DRB Application No.: 06DRB-00350 (P&F)
Project Name: SIERRA BONITA ADDITION
Agent: Terrametrics of New Mexico

CITY OF ALBUQUERQUE
Planning Department
March 22, 2006
DRB Comments

RE: Sierra Bonita Addition/p&f

PLAT OF  
**LOTS 10-A AND 10-B**  
**SIERRA BONITA ADDITION**  
 SITUATE WITHIN  
**PROJECTED SECTION 32**  
**T.11N., R.3E., N.M.P.M.**  
**TOWN OF ALBUQUERQUE GRANT**  
**CITY OF ALBUQUERQUE**  
**BERNALILLO COUNTY, NEW MEXICO**  
 MARCH 2006

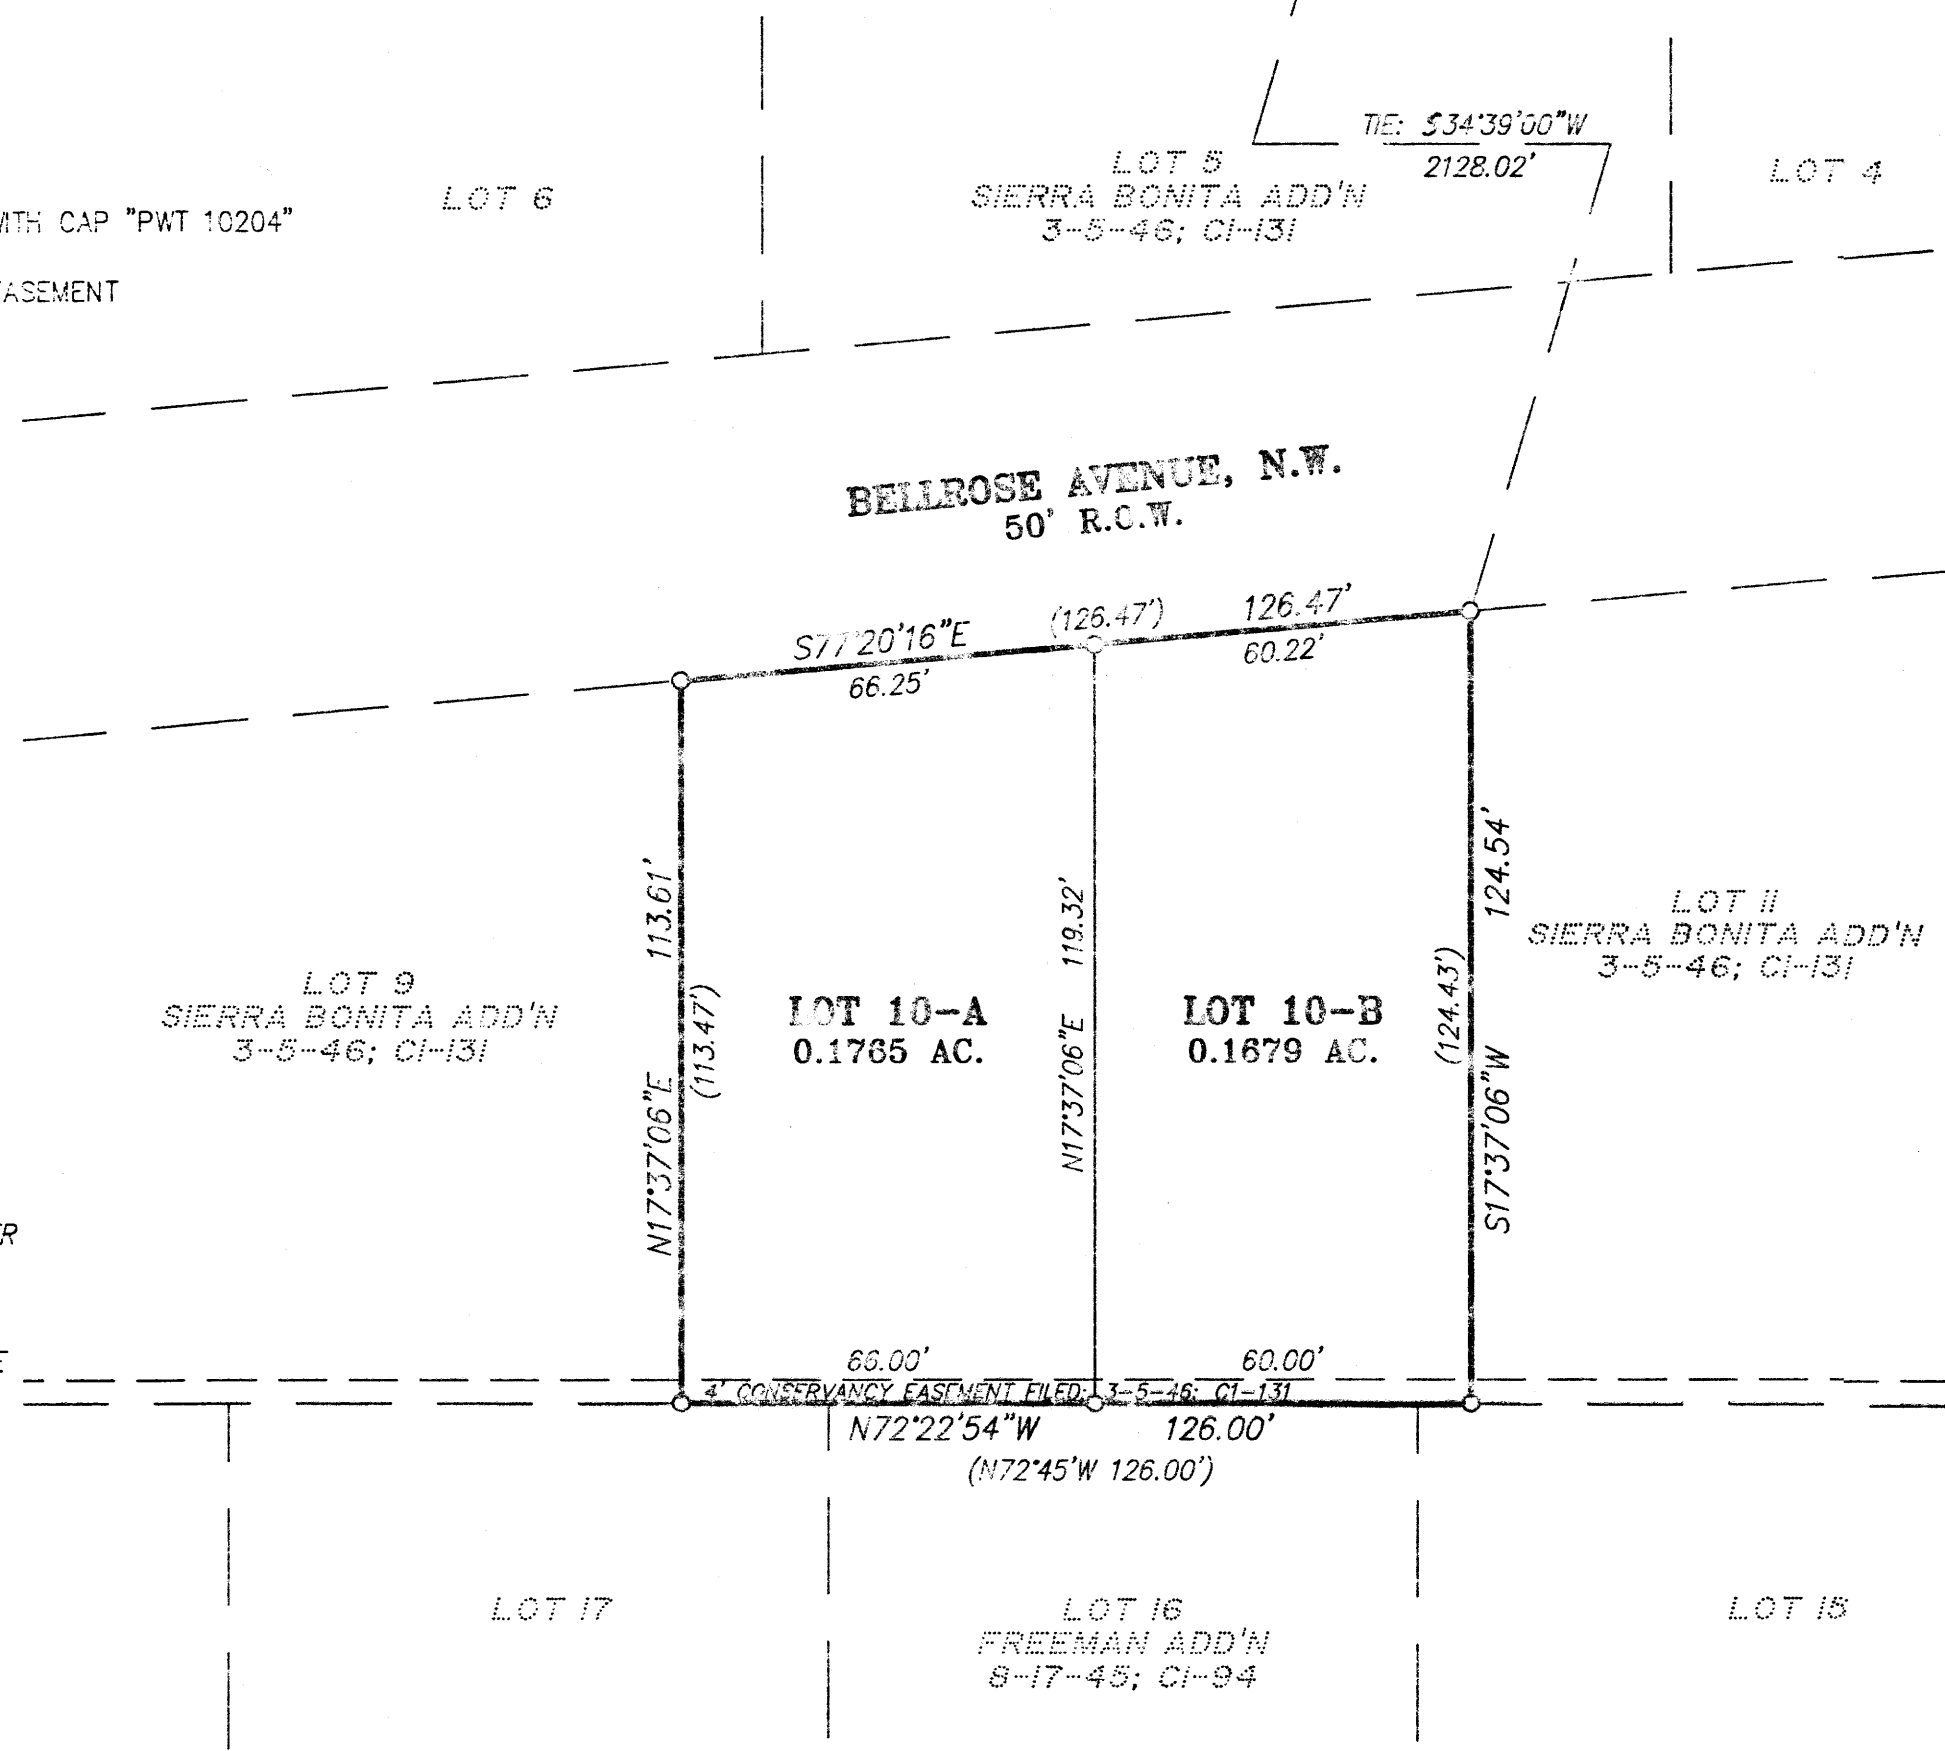
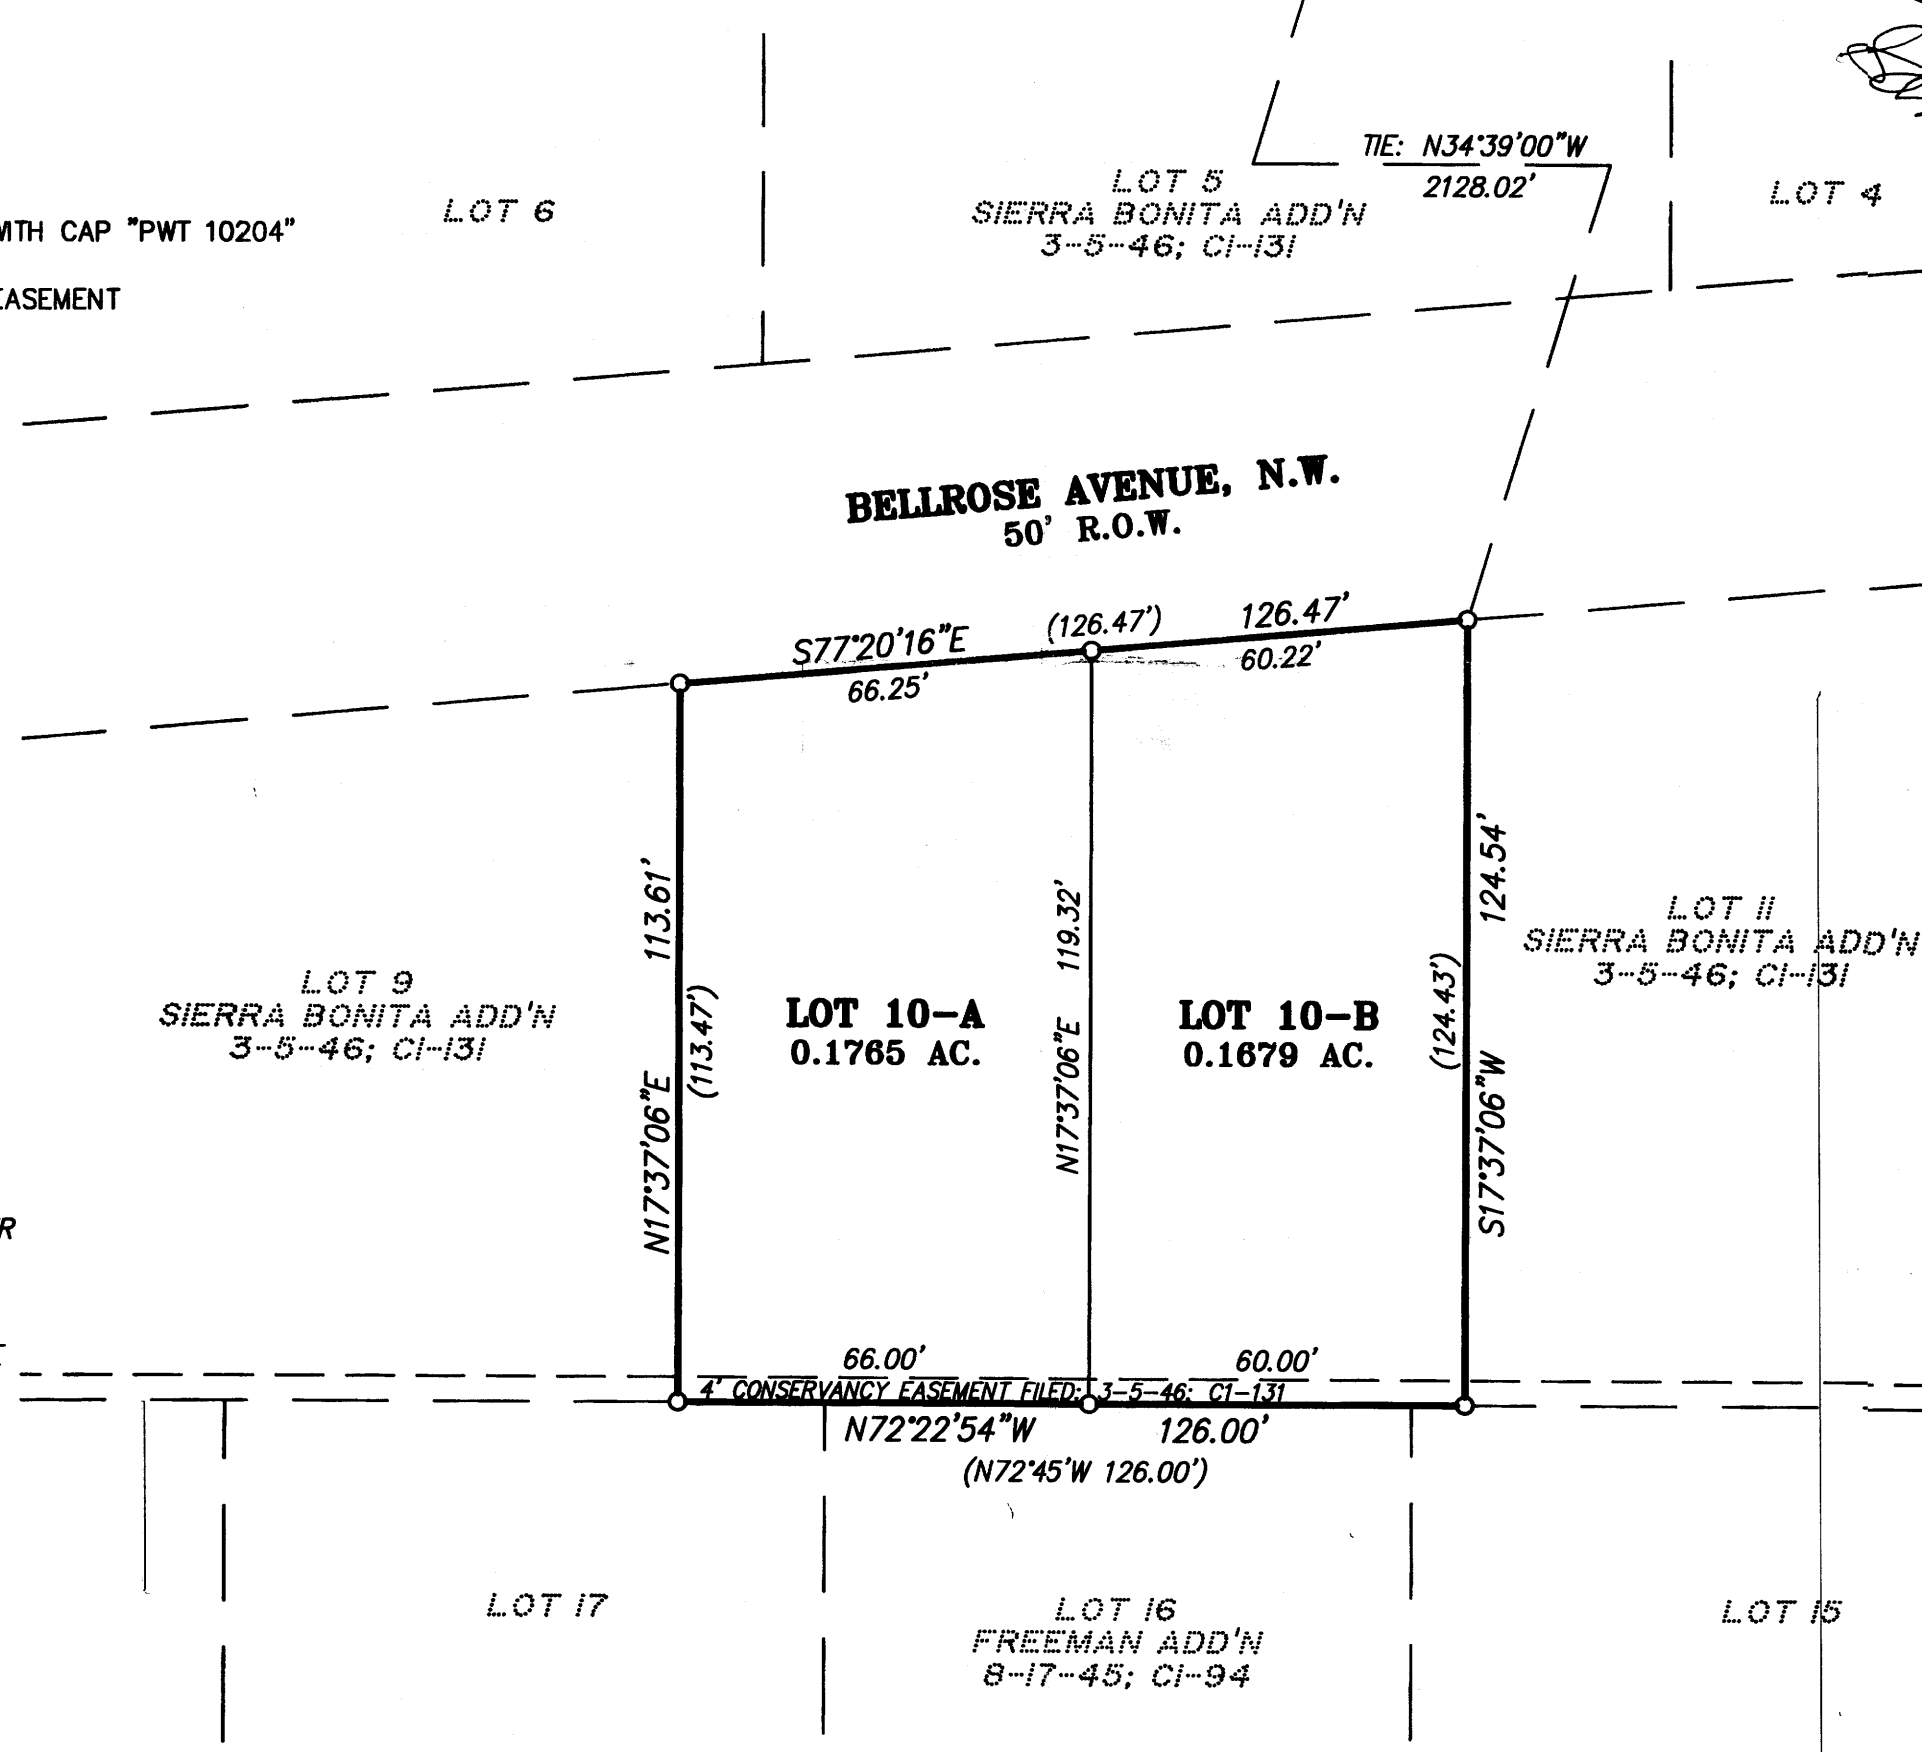
AGIS dxf is not approved. *AK*

Is the structure (accessory building) going to be demolished? If not, is there a 5 foot setback on the east side?

Planning will take delegation for the AGIS dxf approval, and to record the plat.
